# SITE DEVELOPMENT PLAN

## FREEDOM SPRINGS SITE DEVELOPMENT PLAN

Project No.: 18005  
Sheet: 1 of 1

SCALE: 1/64" = 1'-0"

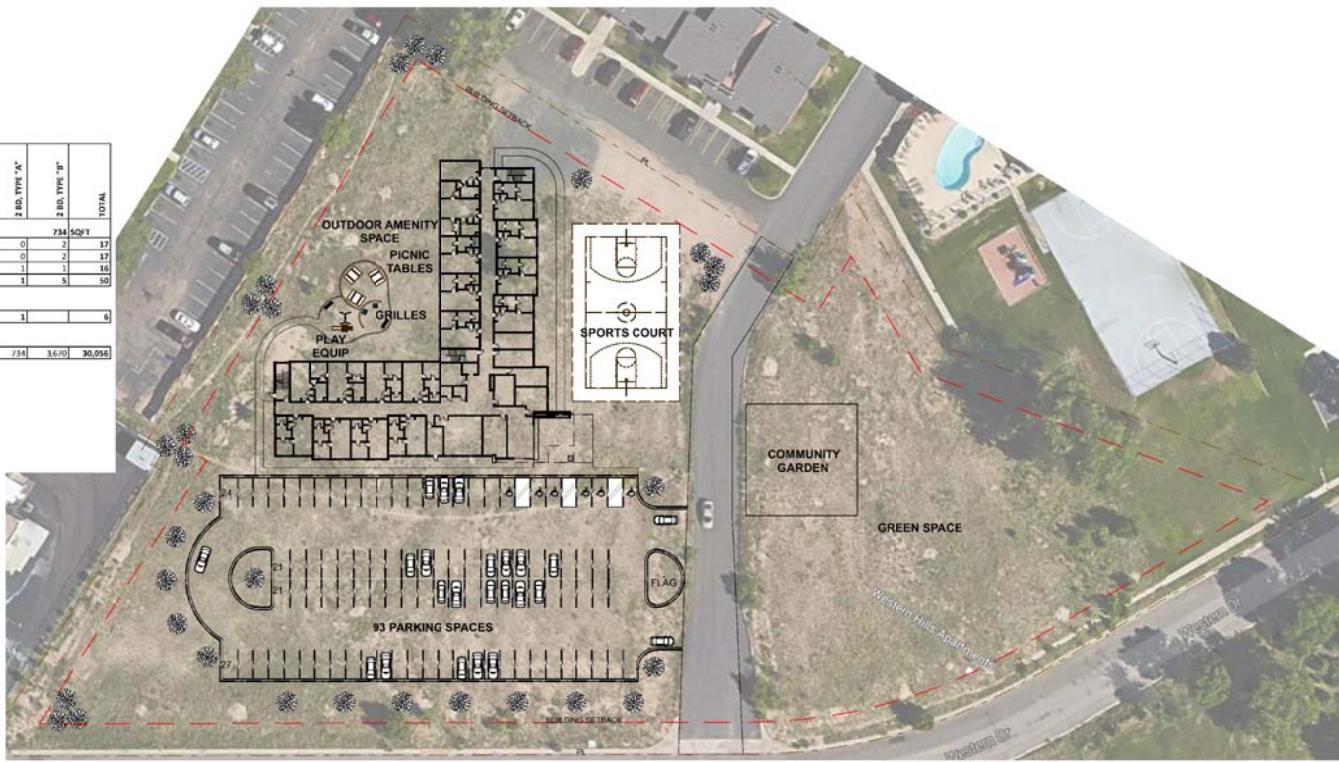
Label pedestrian ramps.

Please provide callout for dumpster location. May be determined to be a structure, approval from the utility company will be required to locate it there.

Provide sidewalks connecting into the site and building.

shared access easement required

The following note should be added to all site development plans or non-residential site plans, as applicable, prior to PCD approval:

"The parties responsible for this plan have familiarized themselves with all current accessibility criteria and specifications and the proposed plan reflects all site elements required by the applicable ADA design standards and guidelines as published by the United States Department of Justice. Approval of this plan by El Paso County does not assure compliance with the ADA or any regulations or guidelines enacted or promulgated under or with respect to such laws."

Also required is an additional page illustrating the ADA route.
